Date: 12 September 2013
Our ref: 97196
Your ref: P/64/13/

Planning consultation: Construction of rock revetment as a coastal scour mitigation measure.
Location: Foreshore West Front Road Pagham PO21 4TB

SSSI - No objection, with conditions

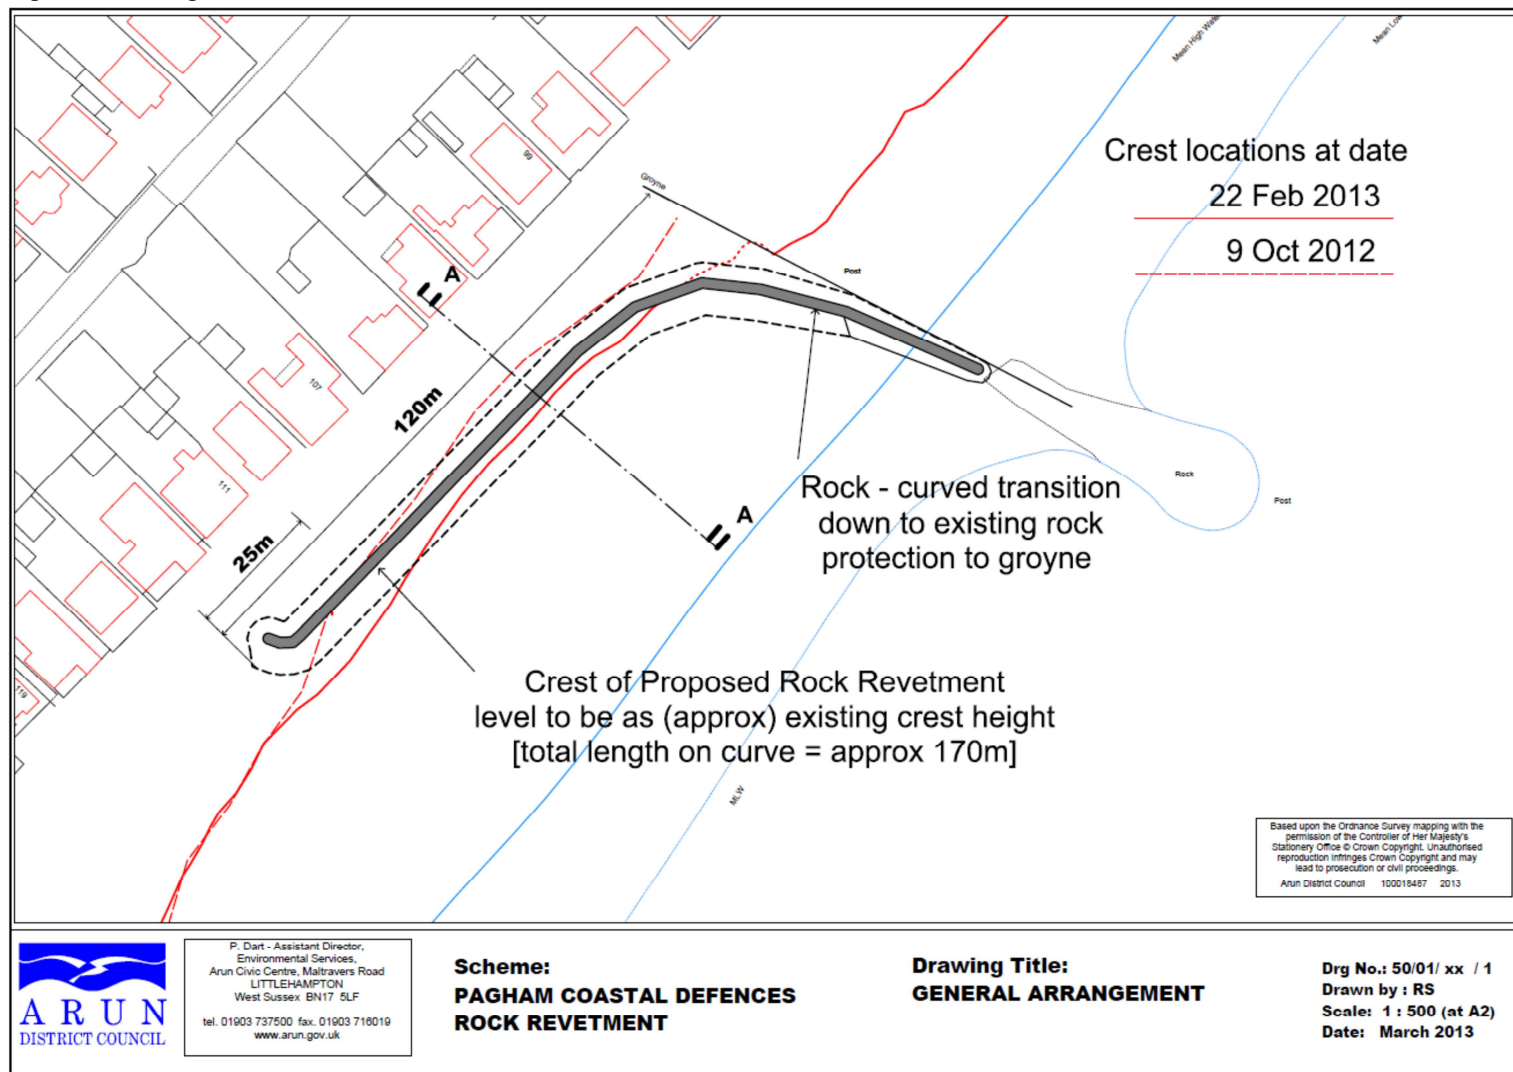
3. Shingle source for possible back fill requirement – Natural England is confident that the sourcing of the proposed small amount of shingle (1,000 m³) for possibly backfilling the revetment, from the area within the inner channel see the ER (Figure 2.4, listed as Figure 2.3 in the text) is unlikely to adversely impact the geomorphology of the site and will not impact significantly on birds feeding during the dates specified. An assent provided by Natural England earlier in the year allowed shingle to be taken from this location and shingle has since accreted. The Environmental Report confirms that sourcing further shingle from this location will not significantly affect the geomorphology of the spit and that shingle will continue to accrete in this area.
